From: Anita Gardner
Sent: 11 December 2012 14:23
To: [REDACTED]
Subject: WA/62/12/CLE Ashogle and Brookview Nursery, Eastergate Lane, Walberton

Having considered the submitted information it is apparent that the red edge to the application site is incorrect. Storage of aggregates takes place outside of the identified building. I would appreciate it if the red edge could be amended to refer to all of the site area relating to the aggregate business use and if the layout plan can clearly identify the specific uses on each part of the site and be annotated accordingly.

SITE BLOCK PLAN @ 1:500
Ordnance Survey, (c) Crown Copyright 2012. All rights reserved. Licence number 100020449

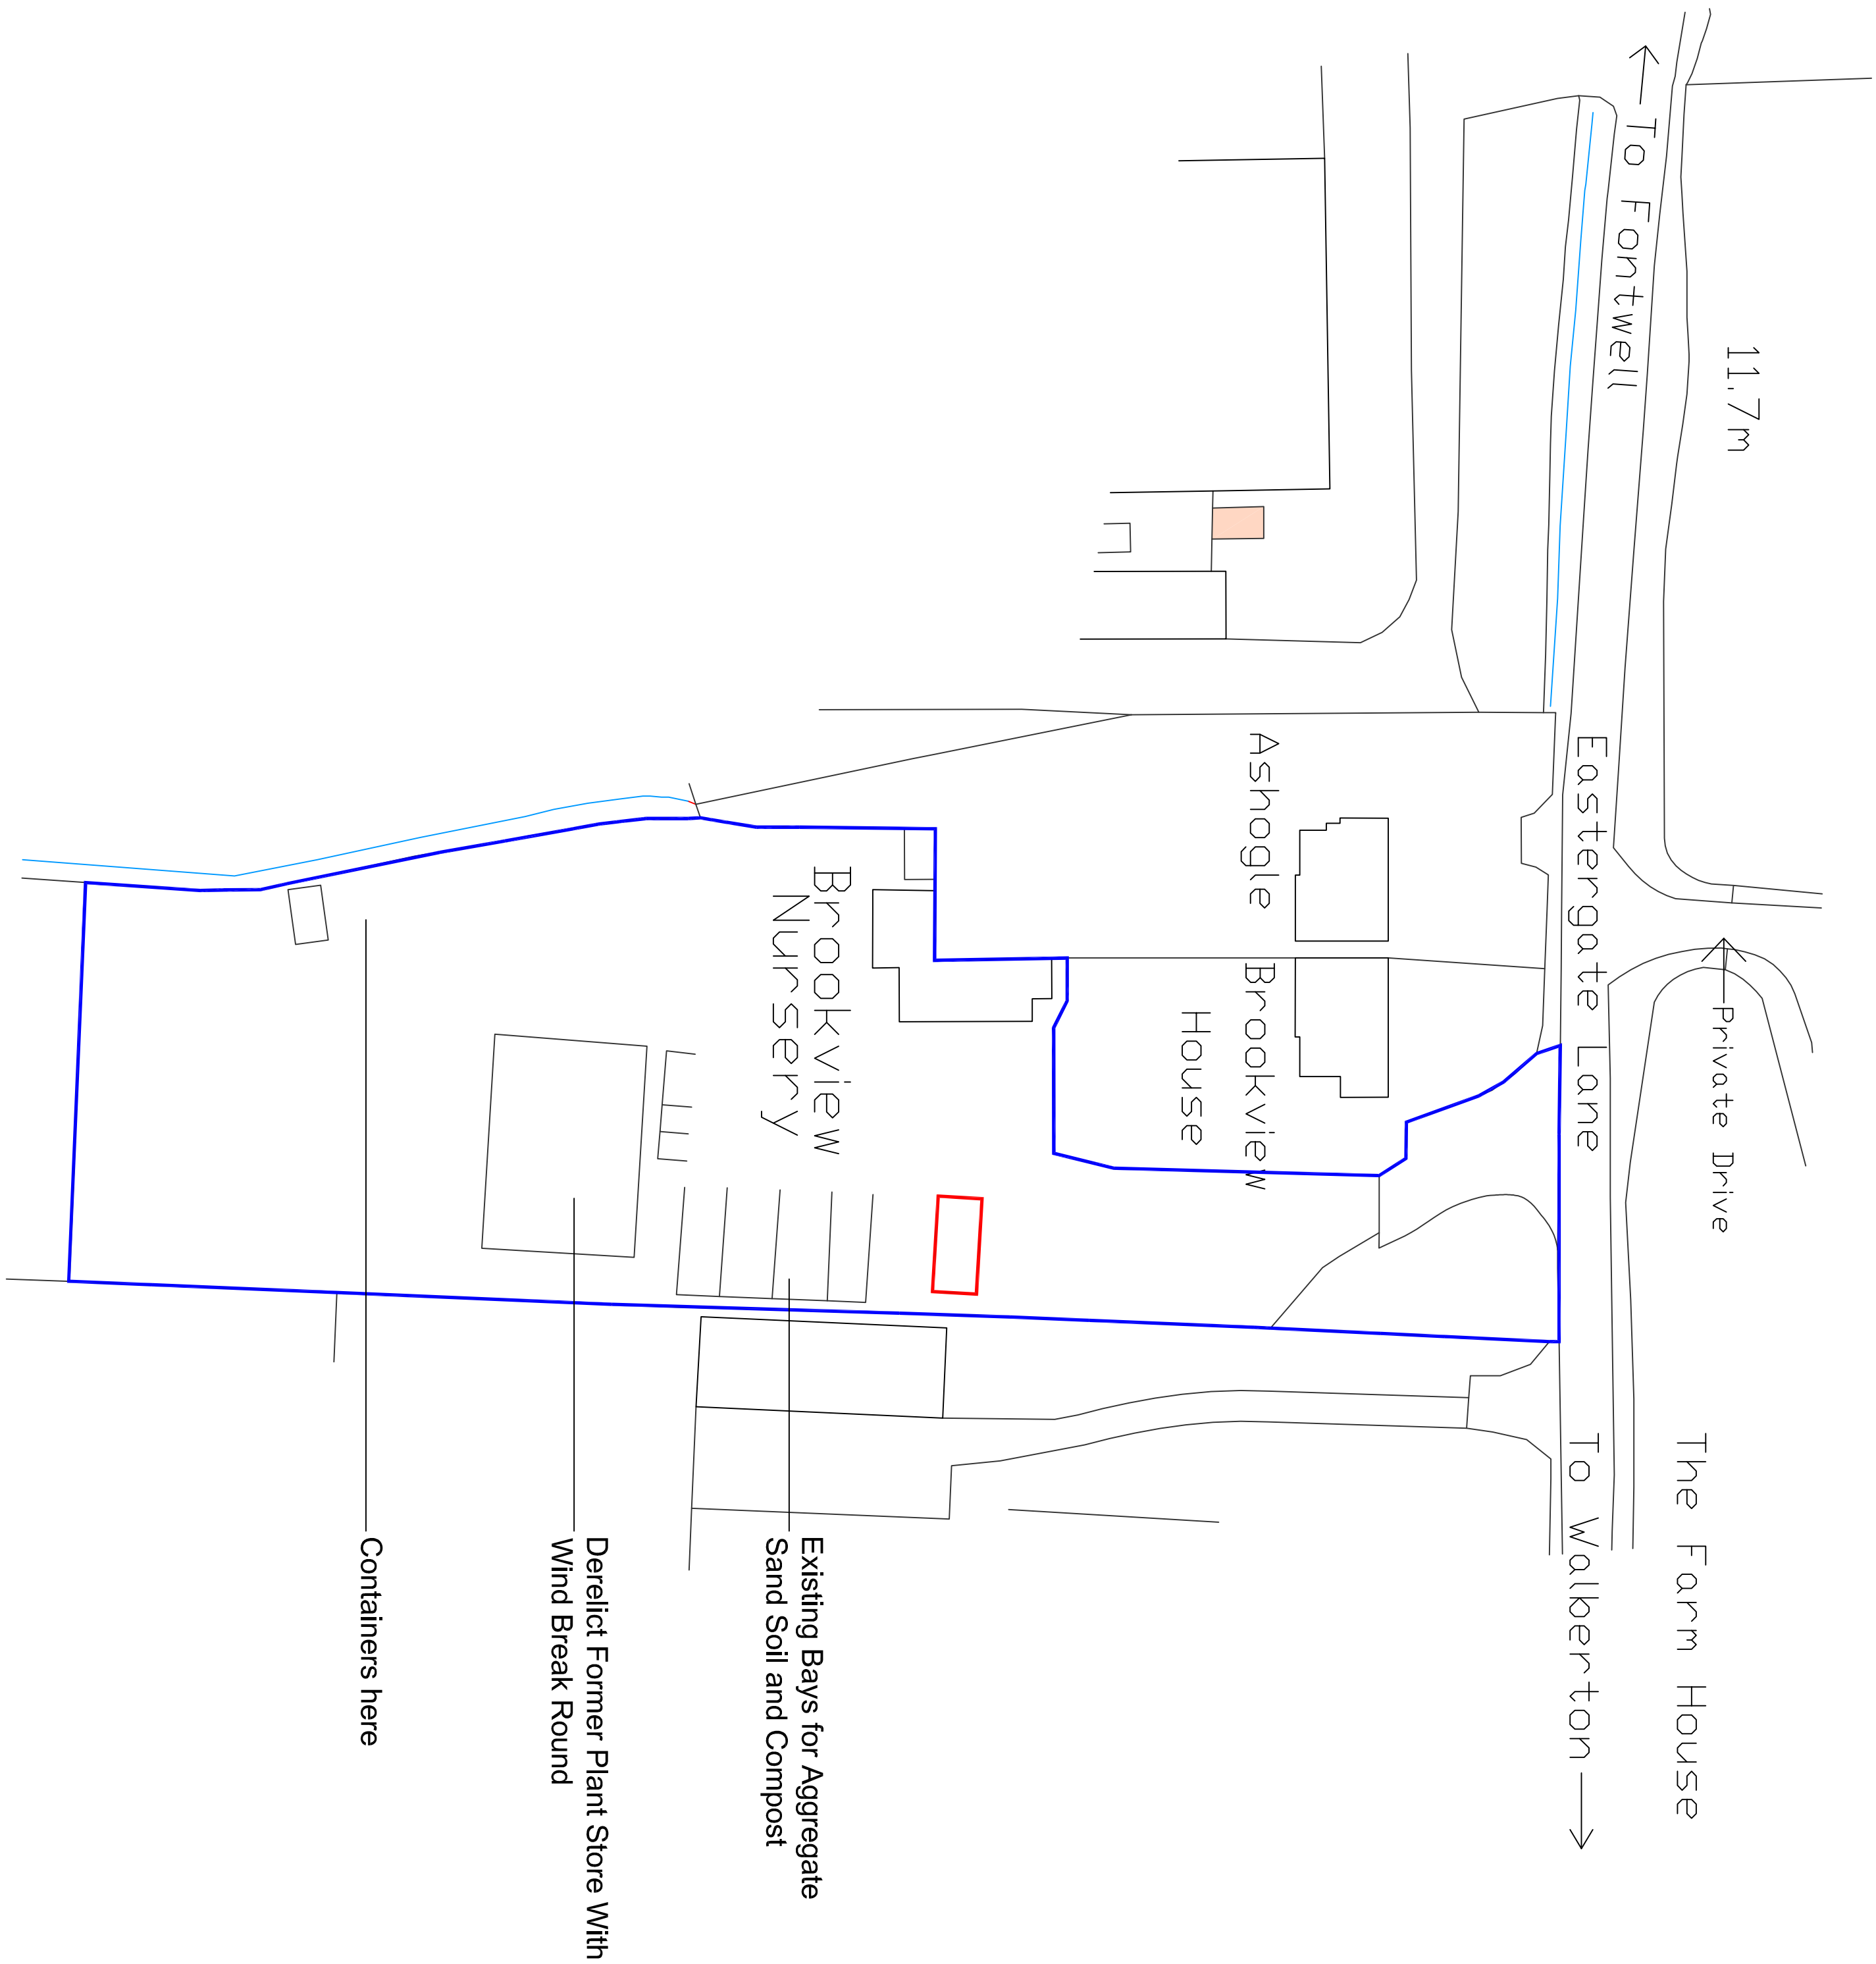
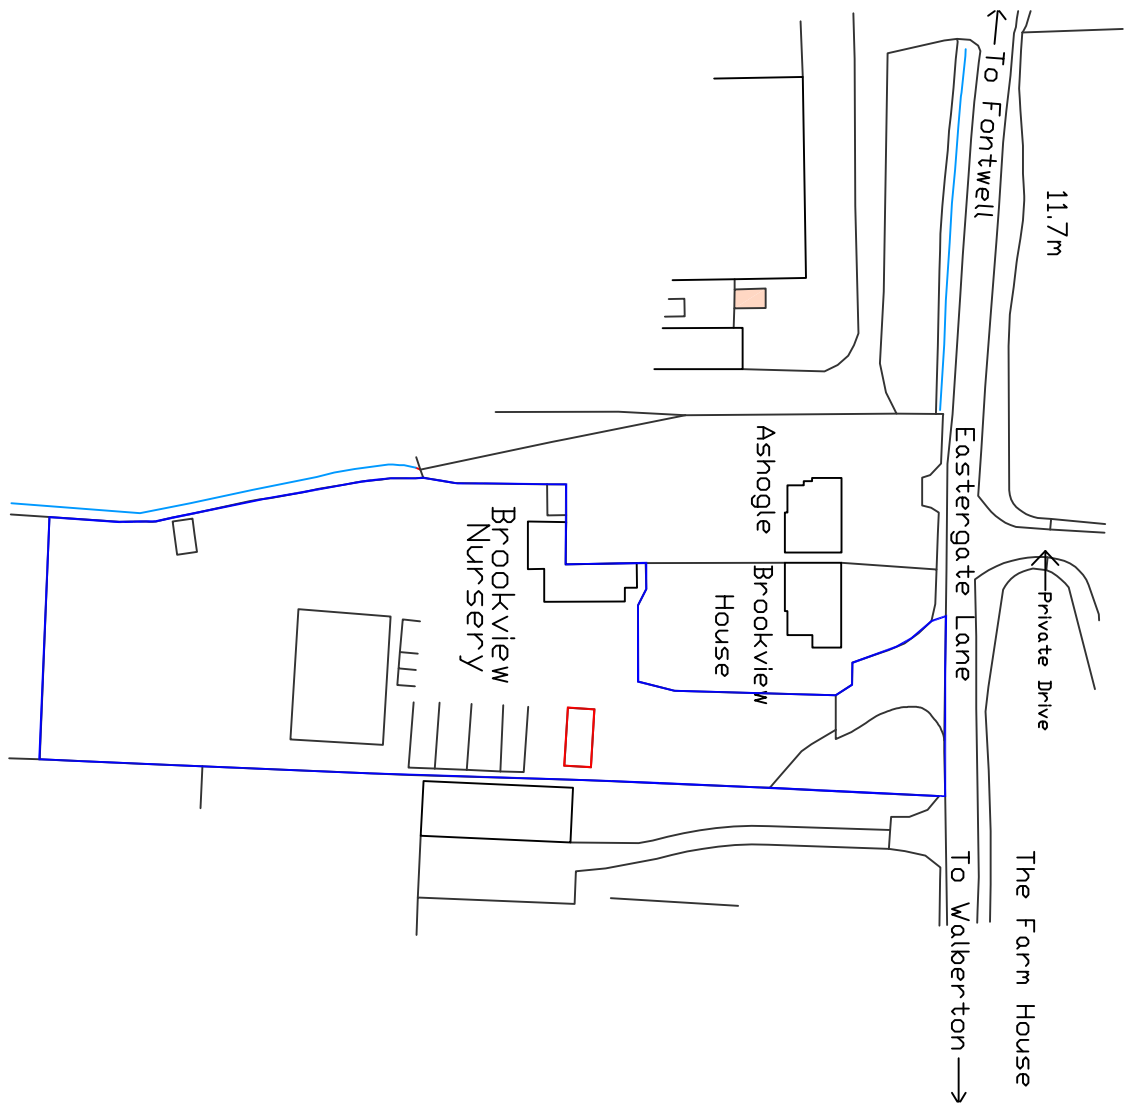
Without prejudice I would appreciate receipt of a revised block and site plan within 14 days of the date of this e-mail.
